DELEGATED HOUSEHOLDER DECISION

Item No. Report of the Head of Planning, Sport and Green Spaces**Address** 50 WINDERMERE AVENUE RUISLIP**Development:** Part two storey, part single storey side/rear extension**LBH Ref Nos:** **70949/APP/2015/3011****Drawing Nos:** DD108-06-P3
DD108-07-P3
DD108-01-P0
DD108-02-P2

DD108-07-P3

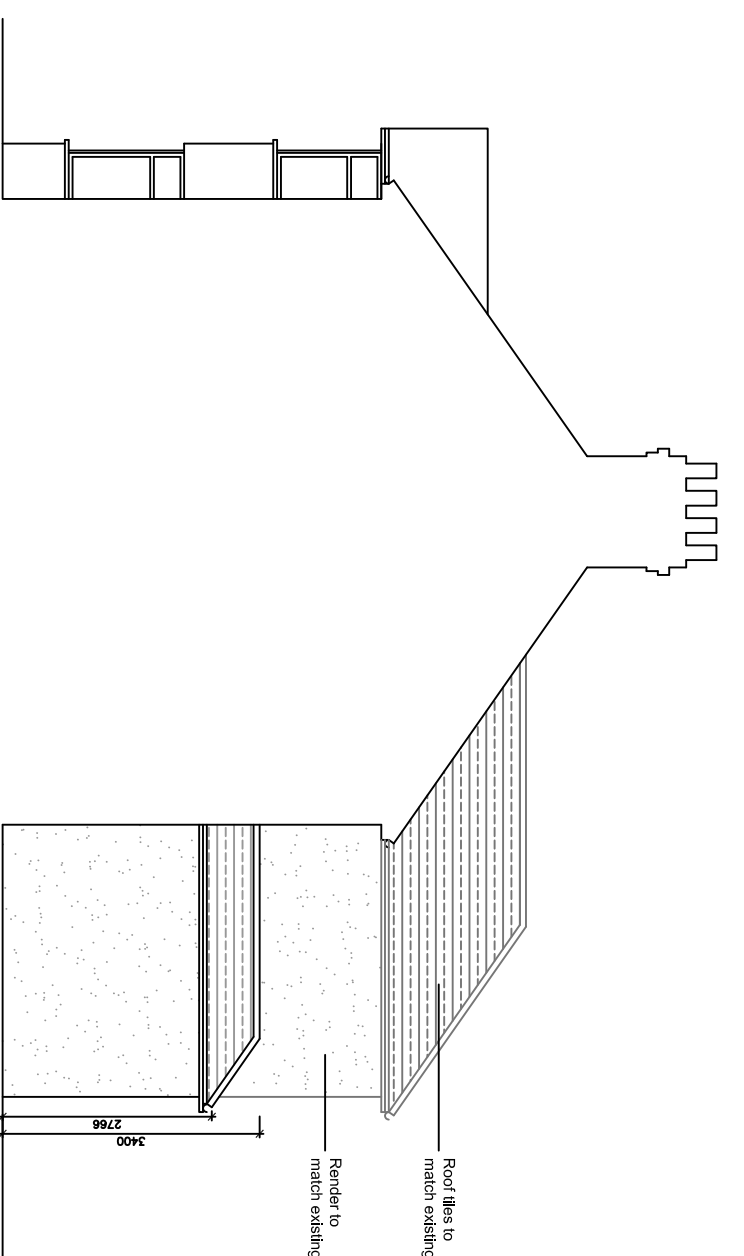
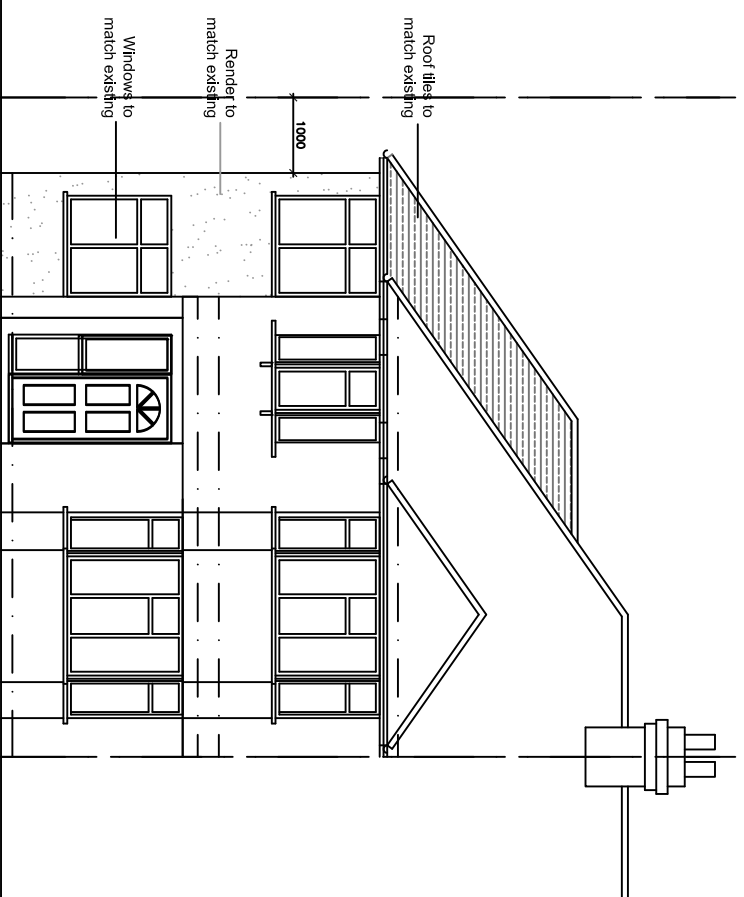
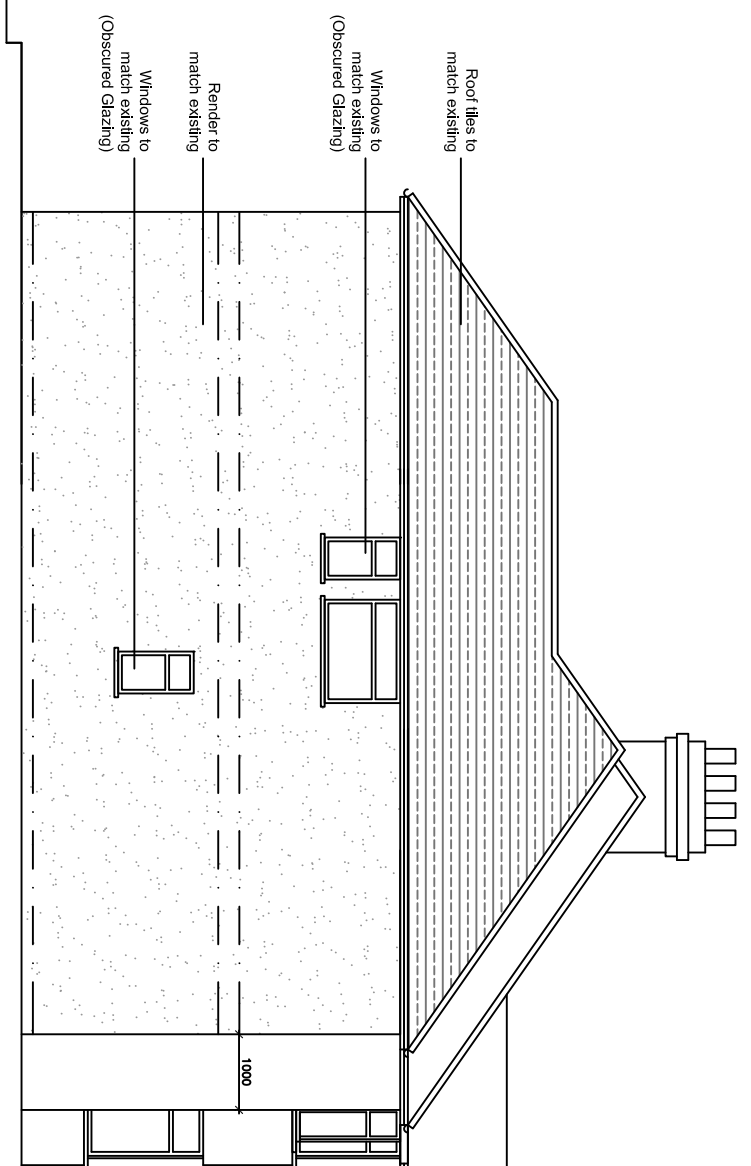
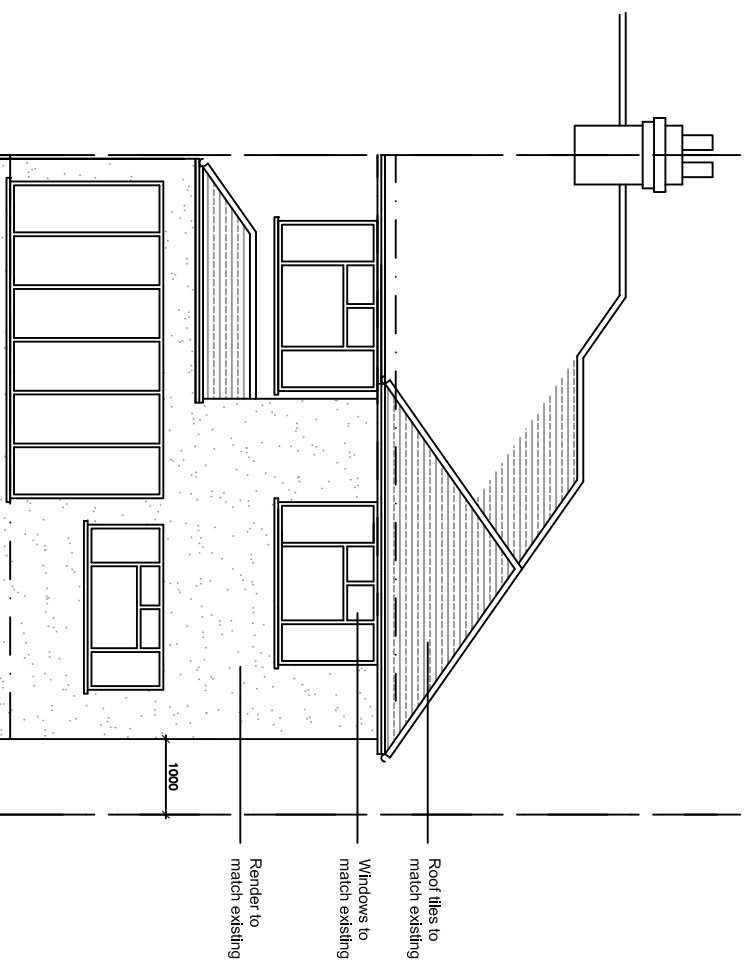
The roof of the proposed development will be approximately 0.58m lower than the ridge of the original roof.

Plans show that the proposed windows on the side elevation, at first floor level, are windows of a bathroom and an en suit, and will therefore be obscurely glazed. Therefore there will be no issues regarding overlooking or breach of privacy.

DRAWING TITLE	
PROPOSED PLANS	
DATE	MAY 2015
SCALE	1:100 @ A3
DRAWING NO.	DD108-06-P3
REVISION	
DRAWN BY	NP
CHECKED BY

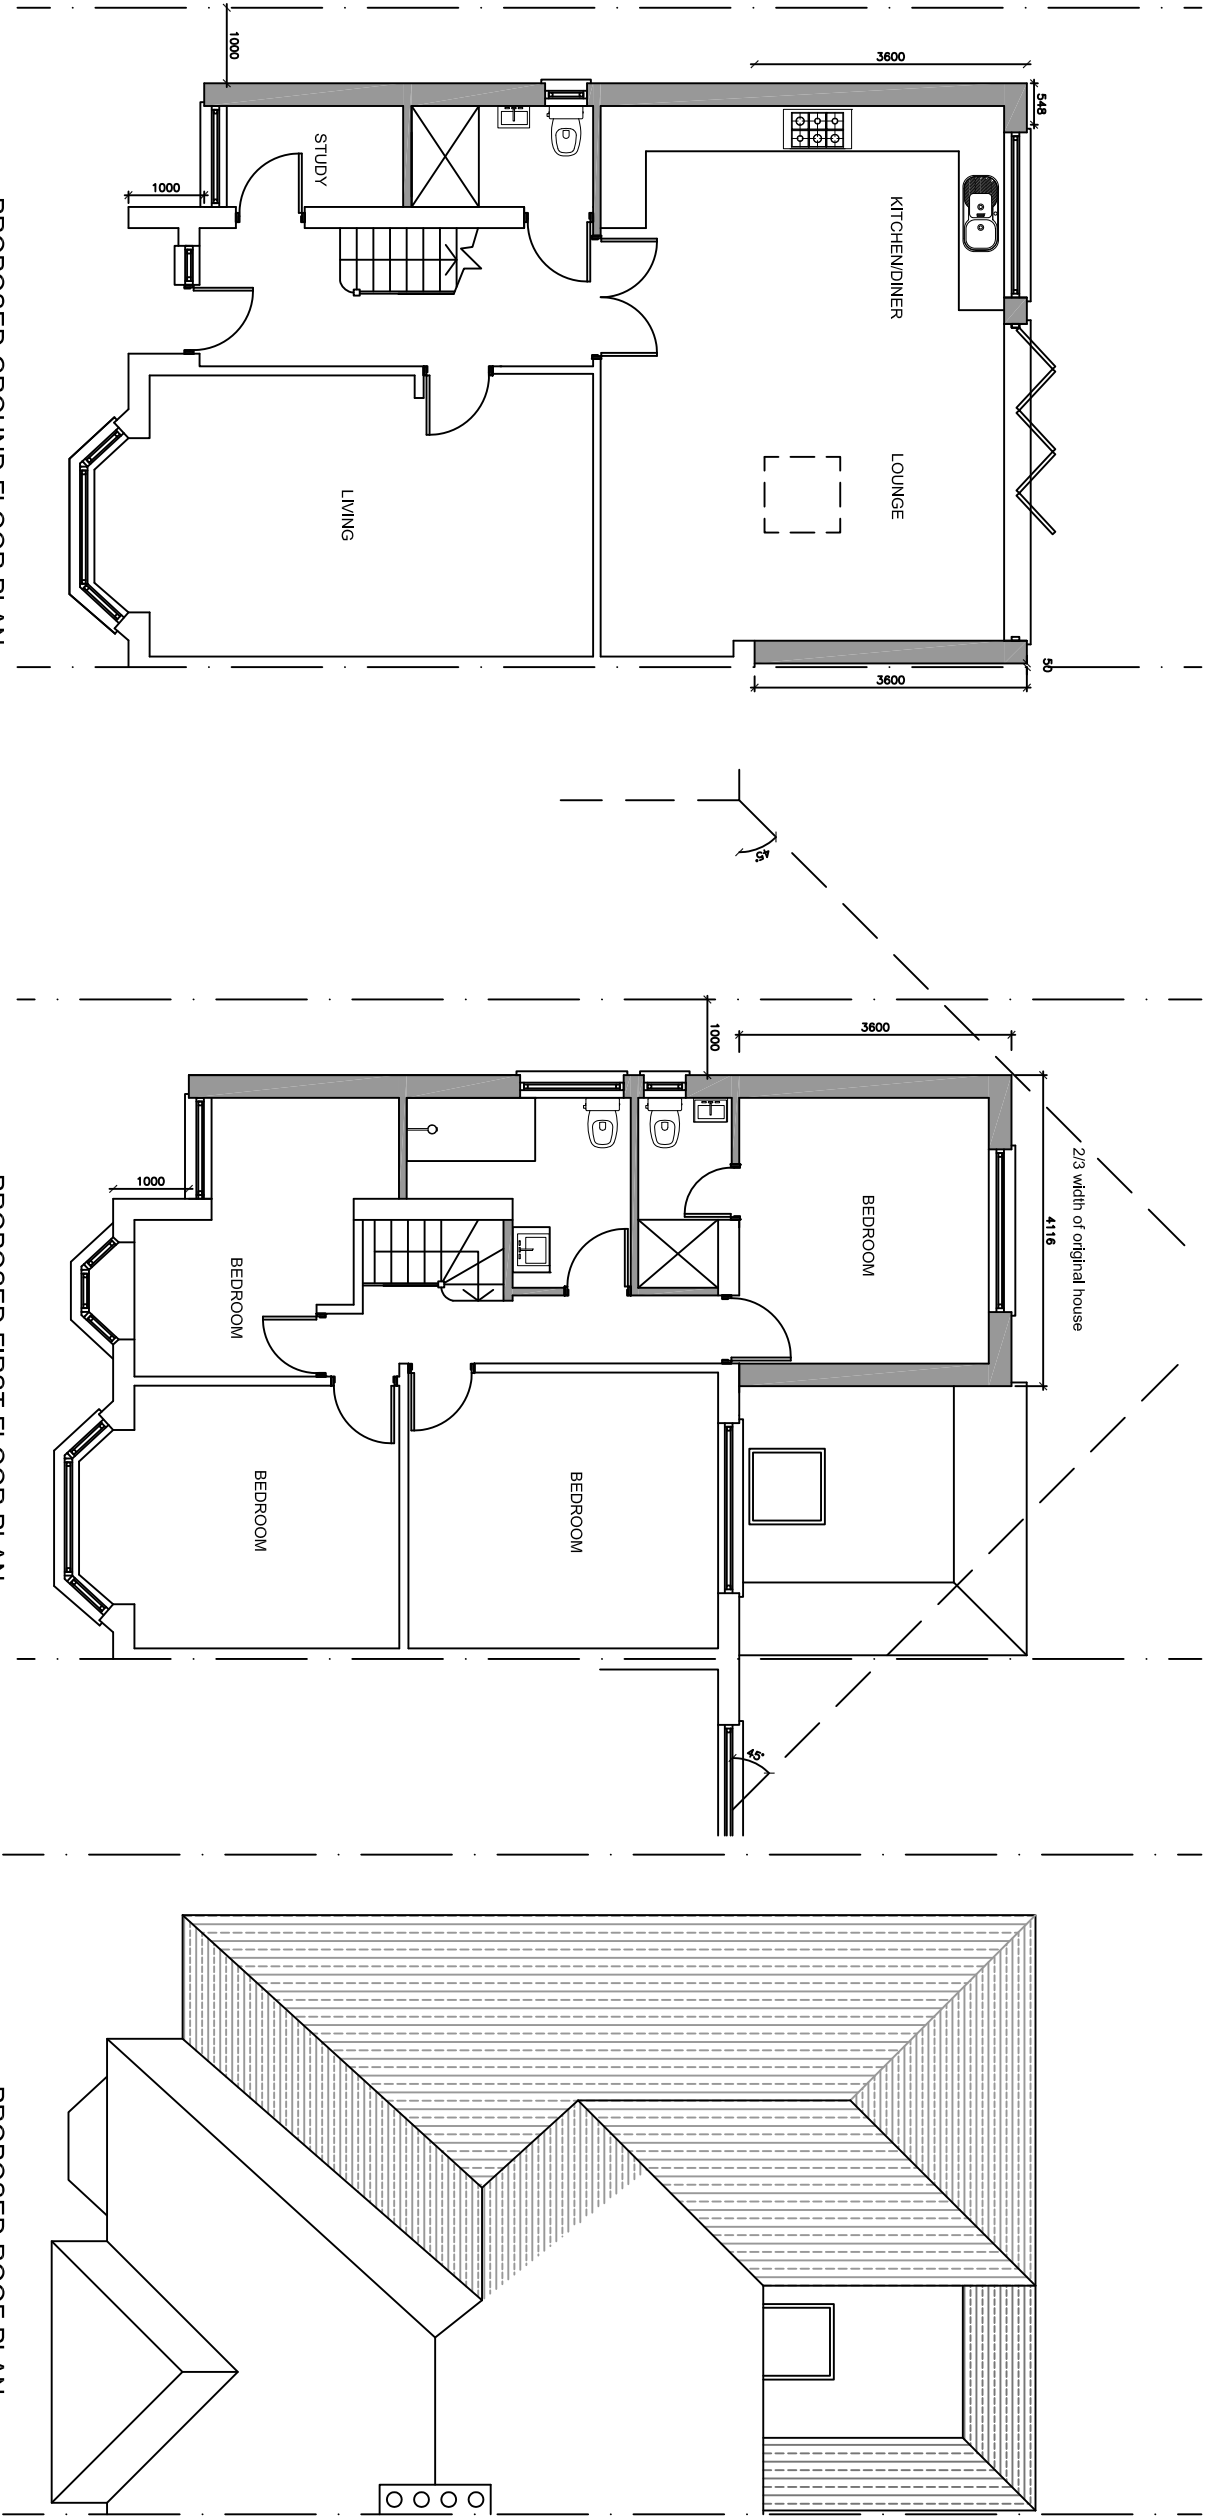
The proposed two storey side extension element of this development will be set in from the side boundary, shared with no.48 Windermere Avenue by 1m. This is considered to be an acceptable set in from the boundary, as it does not create a terracing effect, as the property will still visibly read as a semi-detached dwelling.

Plans show that the proposed two storey side extension will be set back from the front wall of the original dwelling by 1m.

The proposed two storey side extension element of this development will be 1.63m wide, which is less than half and two thirds the width of the original house, which is 5.91m wide. The length of the proposed side extension is 10.97m, and will wrap around the proposed rear extension.

The proposed single storey rear extension will have a depth of 3.6m and will have a width of 7.68m. The proposed single storey rear extension will have a pitched roof with a height 3.4m.

The first floor rear extension will not extend beyond a 45-degree angle, ensuring no over dominance, overshadowing or loss of outlook. The proposed two storey rear extension will have a depth 3.6m and will be approximately 4.13m wide.

With regards to objection 2 and 3, the proposed development will be set in from the side boundary shared with no.48 Windermere Avenue by 1m, which is considered to be an appropriate separation distance. Furthermore the proposed first floor rear extension does not breach the 45 degree line of sight, ensuring there will be no overshadowing, loss of light or loss of outlook to the occupiers of no.48 and no.52 Windermere Avenue.
